Your ref: EN010098
ESC Reference: 20029880
Date: 25/03/2022
Please ask for: Grahame Stuteley
Customer Services: 03330 162 000
Direct dial: [REDACTED]
Email: energyprojects@eastsoffolk.gov.uk

Re: Application by Ørsted Hornsea Project Four Limited for an Order Granting Development Consent for the Hornsea Project Four Offshore Wind Farm – East Suffolk Council’s response to the Applicant’s Deadline 1 submissions - Examination Deadline 2 (Tuesday 29th March 2022).

Figure 2 Updated Compensation Measure search areas.

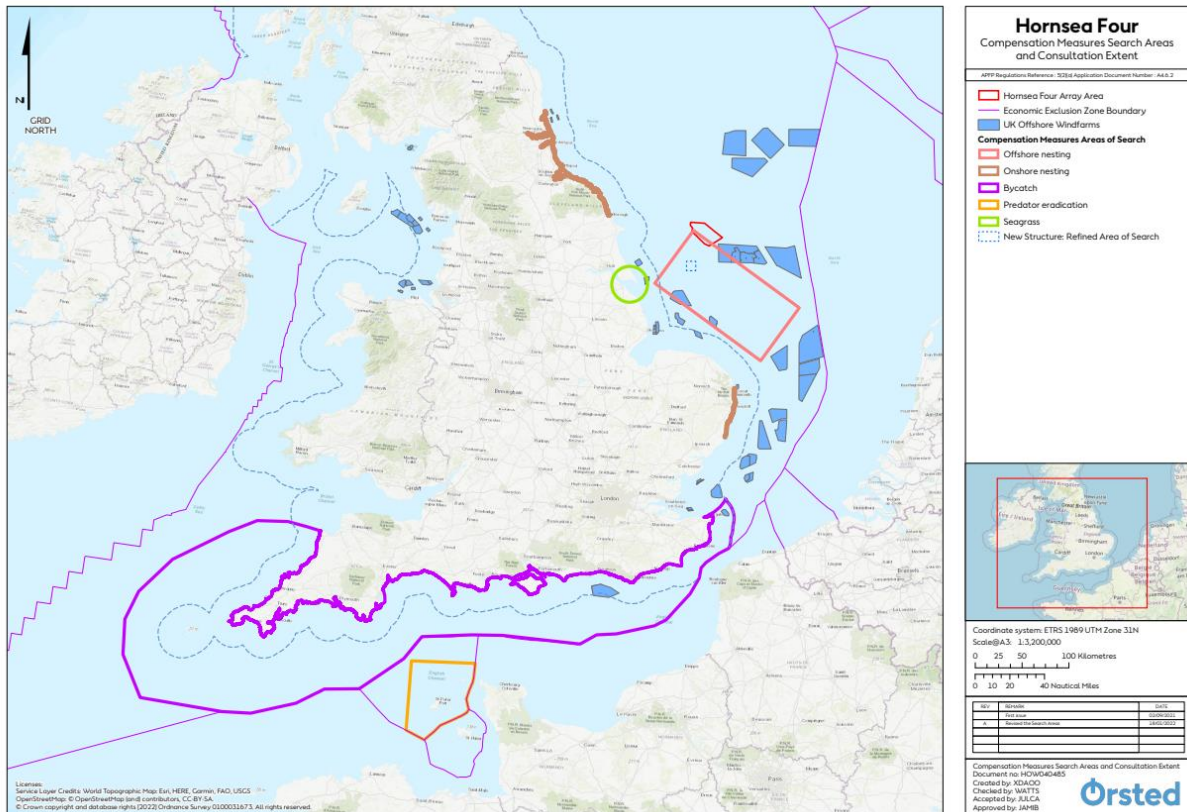
It is understood that the Hornsea Four project intends to construct an ANS within one of the search areas indicated in Figure 2 (REP1-071) with the possible offshore nesting structure search area being located off the coast of the Flamborough and Filey Coast SPA in the southern North Sea, and two areas of search for onshore nesting structures, one in East Suffolk, and the other from Clyton Bay to Newbiggin by the Sea in the north east of England.

ESC supports the Applicant's preference to provide an ANS offshore by repurposing an existing structure and would have significant concerns regarding the siting of a nesting structure within our coastal area. The terrestrial planning constraints associated with an onshore structure can significantly constrain site availability, as in the coastal areas of East Suffolk with its highly designated and visually sensitive landscape. The provision of an ANS onshore or in the nearshore area in East Suffolk would therefore be significantly challenging.

Figure 5: Compensation measures area of search: Onshore Nesting – Suffolk Coast.

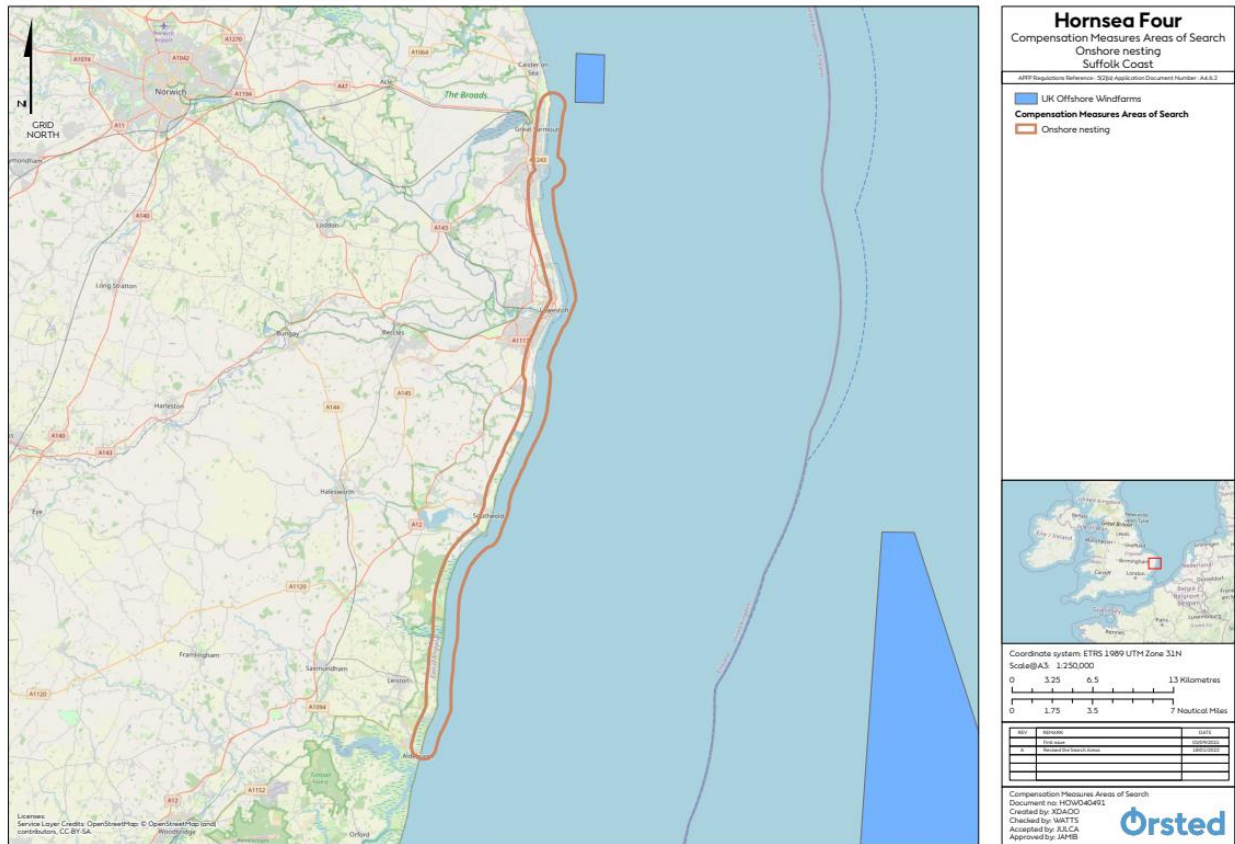
accommodate both projects, if found to be viable, would be supported by ESC. ESC would however have significant concerns if an onshore or nearshore structure was proposed to be provided within the East Suffolk locality. Notwithstanding this position, unless an onshore or nearshore option in East Suffolk is discounted, it is essential that we are engaged in discussions on this matter at the earliest opportunity.

As stated previously, ESC will raise significant concerns to the siting of ANSs in our coastal areas. If however an offshore structure is not found to be viable, clear justification needs to be provided for any ANSs proposed on the East Suffolk coastline. Notwithstanding the Council's position, if an onshore or nearshore proposal is advocated in East Suffolk, we would need to be satisfied that every opportunity for coordination between
